ILC – OG745

## ADDENDUM ASSESSMENT REPORT

### **Modification No.8 to Major Project MP 05\_0147 – Intermodal Logistics Centre (ILC) at Enfield: Subdivision Changes and Amendments**

PLAN OF PROPOSED SUBDIVISION OF THE INTERMODAL LOGISTICS CENTRE COSGROVE ROAD, ENFIELD

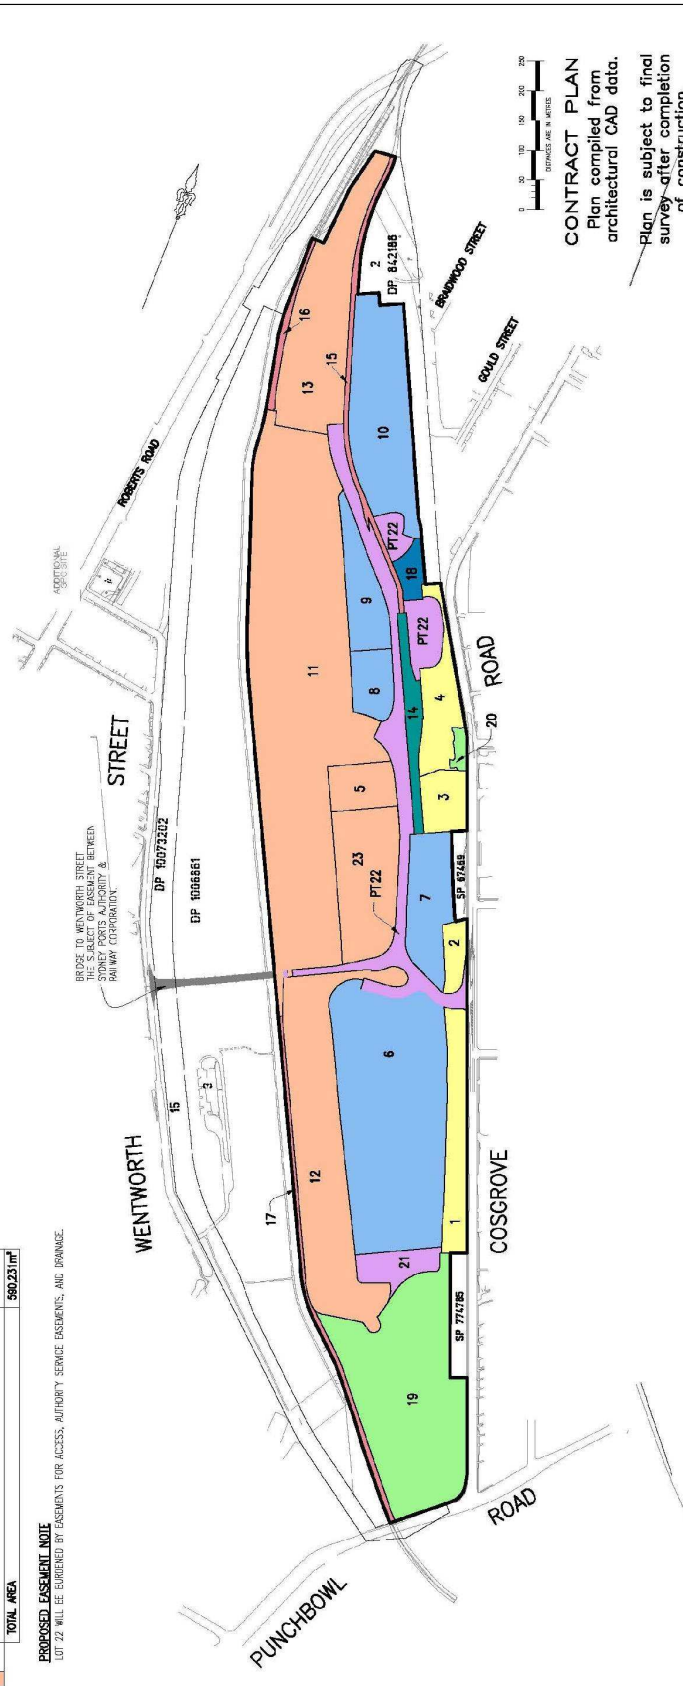
Section 2.2 of the Assessment Report outlines the proposed subdivision amendments. In addition to the amendments described in the Assessment Report, NSW Ports proposes to modify the subdivision layout of the ILC site (as shown in Figure 2 of the Assessment Report i.e. DWG: 120225SUB-7 issue 10 dated 5 April 2013) by reducing the allotment size of Lot 22. The details and reasons for proposing these further amendments are outlined below:

- Part of Lot 22 adjoining Lot 6 is proposed to be modified. The previously approved subdivision layout (i.e. Figure 1 of the Assessment Report) showed part of allotment 22 adjoining the property boundary of Lot 5. This portion of land was required to provide vehicular access from Cosgrove to Lot 5. Due to the amalgamation of Lots 5 and 6 into one allotment (i.e. Lot 6 under the current proposal), the access road to the west of Lot 6 is no longer required. This portion of land is therefore proposed to be incorporated into Lot 6.

- Part of Lot 22, which adjoins Lots 8 and 11, is also proposed to be modified. Similar to the above, vehicular access is required to be provided to both Lots 8 and 11. The previously approved subdivision layout extended the road access area into allotment 11 more than what is required under the current leasing arrangement. In order to maximise the use of Lot 11 for leasing purposes and to facilitate development works proposed to be undertaken by the ILC terminal operator, it is proposed to reduce the area of allotment 22.

It should be noted that the small portion of land adjoining Lots 11 and 12 (i.e. land shaded purple) marks the road bridge footing. This parcel of land forms part of allotment 22.

As part of the final land survey and registration of the subdivision plan, further minor boundary adjustments could be made to the subdivision layout shown in Figure 2, similar to those described above. It is noted that condition of approval 1.15 requires the subdivision plan to be generally in accordance with the approved plan and that the final subdivision plan must be submitted to the Director-General prior to registration.
